APPLICATION LU/265/14/HH
NO:

Site Address: 59 Arundel Drive Thornlea Park Lyminster Road Littlehampton
BN17 7PY

Description of Works: Enclosed porch to west elevation. This application may be determined by Littlehampton Town Council under delegated powers

Re Alterations to 65 Arundel Drive, Thornlea Park, Littlehampton.
Caravan Sites & Control of Development Act 1960
Mobile Homes Act 2013

proposed plan

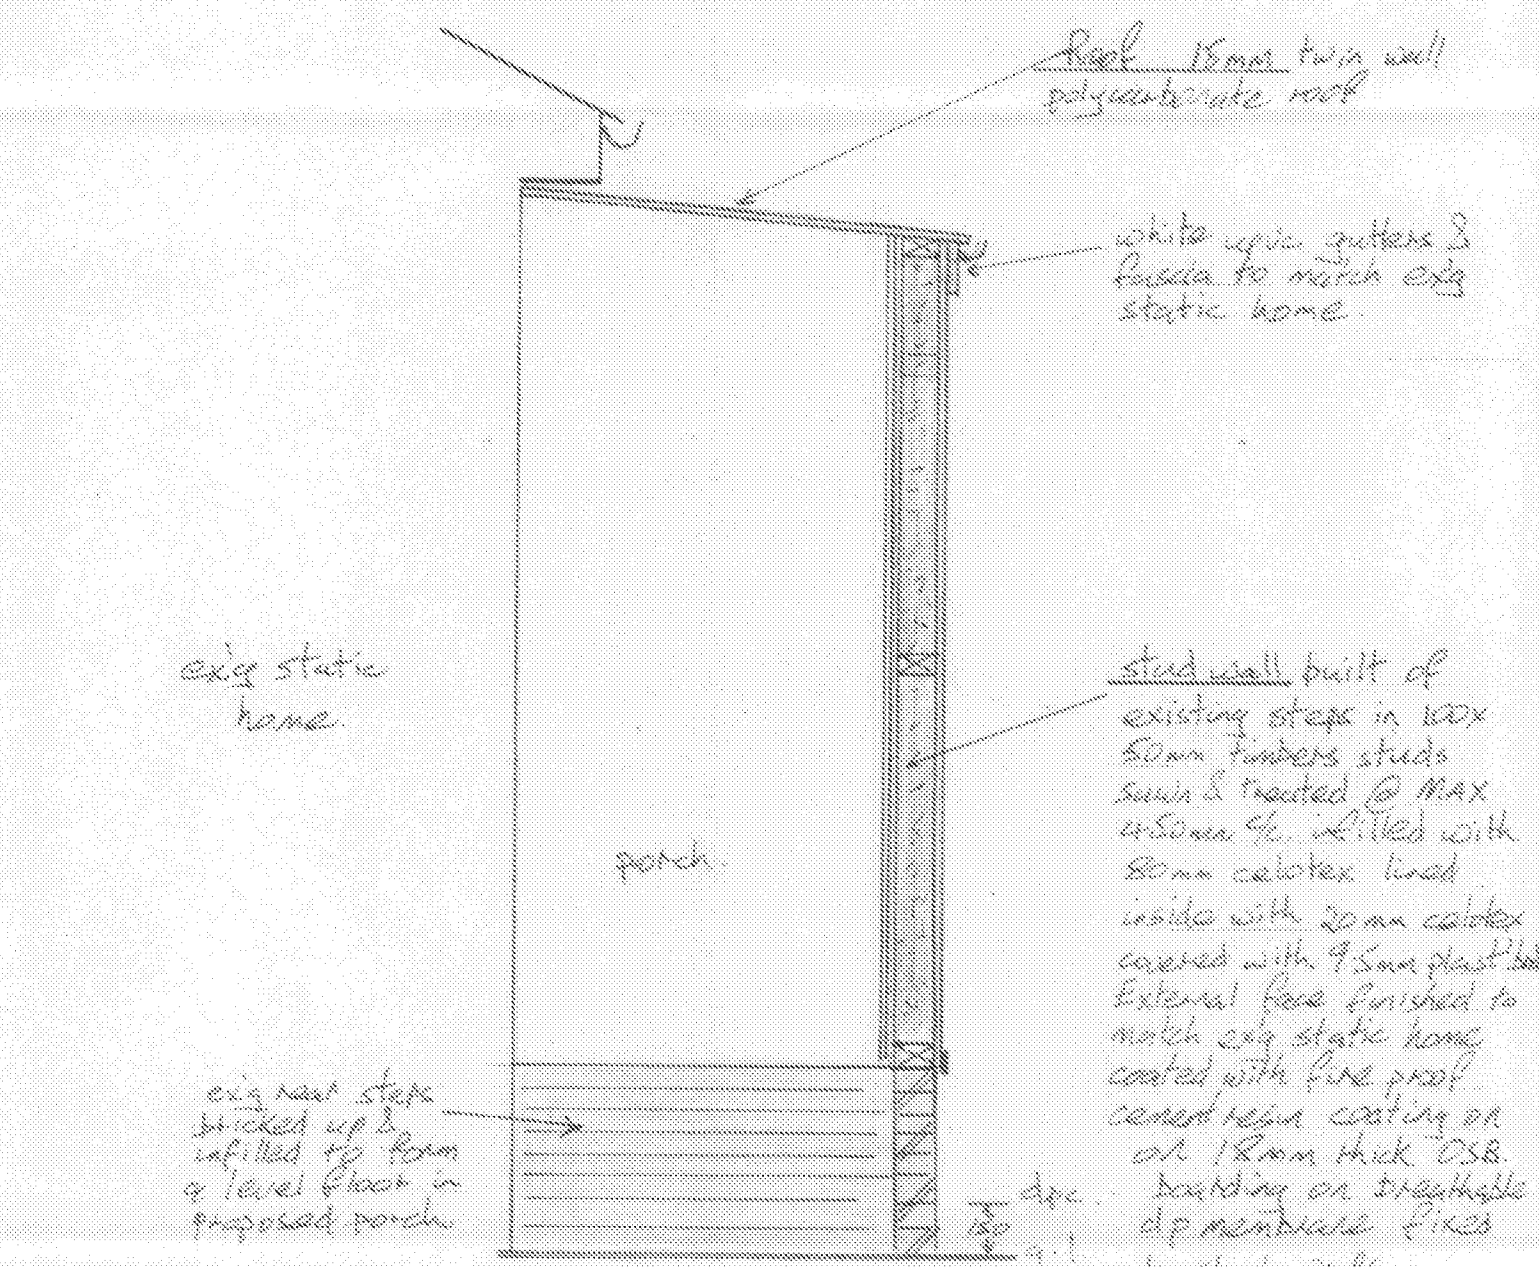
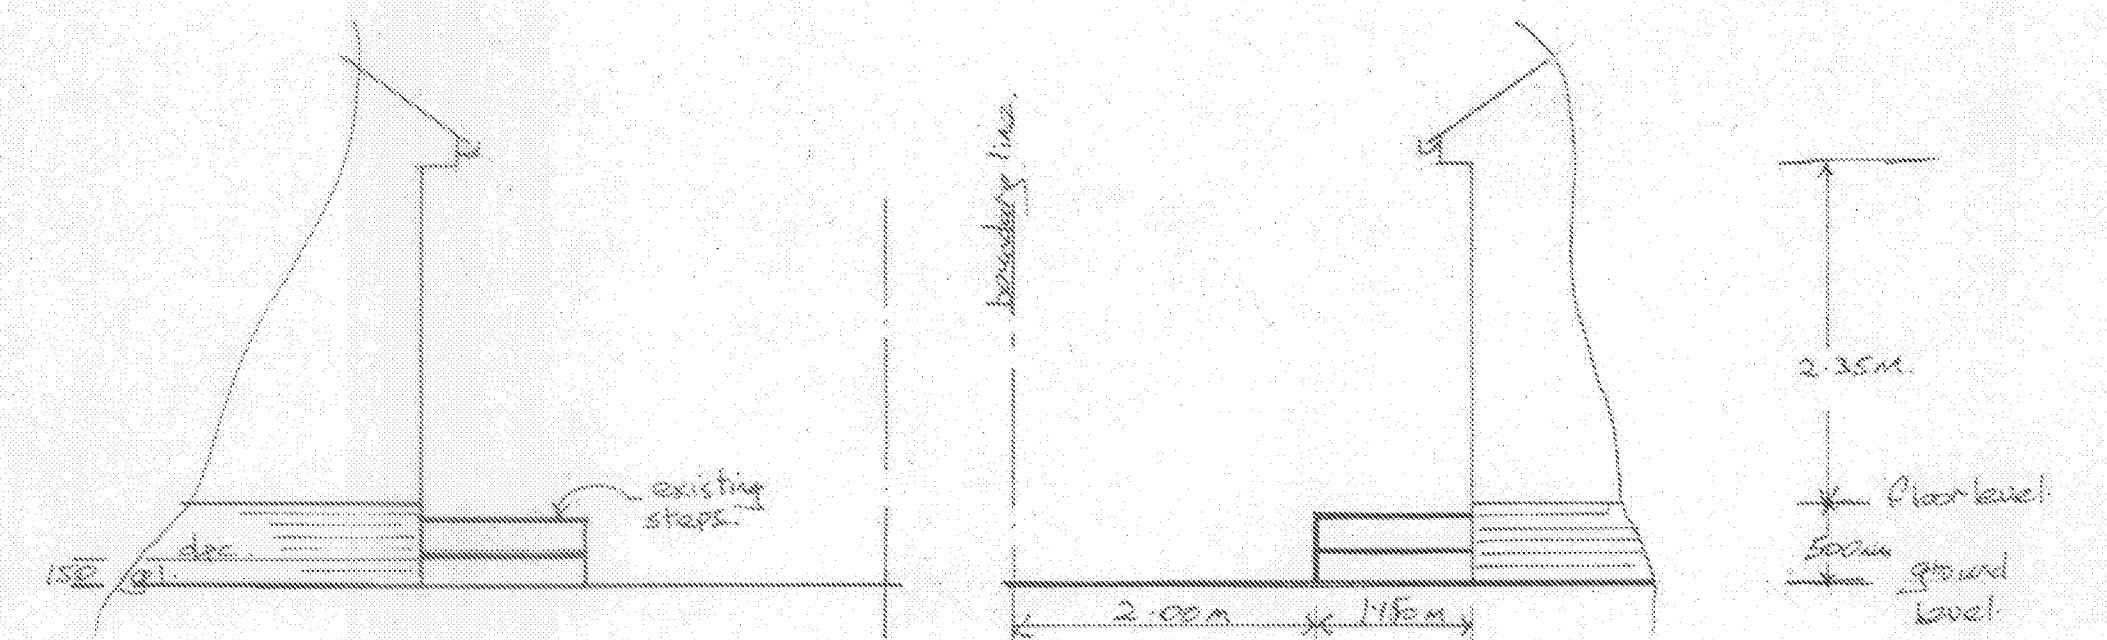
The proposals do not quite comply with the licence conditions as there should be a 4.5m clear distance between any such structure and any adjacent caravan. From the measurement that I obtained at the front of the caravan I believe that you may have 4.5m clear distance as required but this will not be the case further down between the platform at the door of no. 65 and the adjacent caravan.

I can confirm that the proposals and plans are likely to contravene the Caravan Site Licence conditions but the health and safety and amenity of the site are not affected therefore we give permission for the proposed changes provided that this new structure does not form part of the park home structure, (i.e. is not fixed to the park home). The new structure should also be constructed of non-combustible materials and should be removed, replaced or reduced in size so that it does comply with the relevant conditions when Mr Parker ceases to reside at this address. We will also consult with WSCC Fire Service on this proposal.
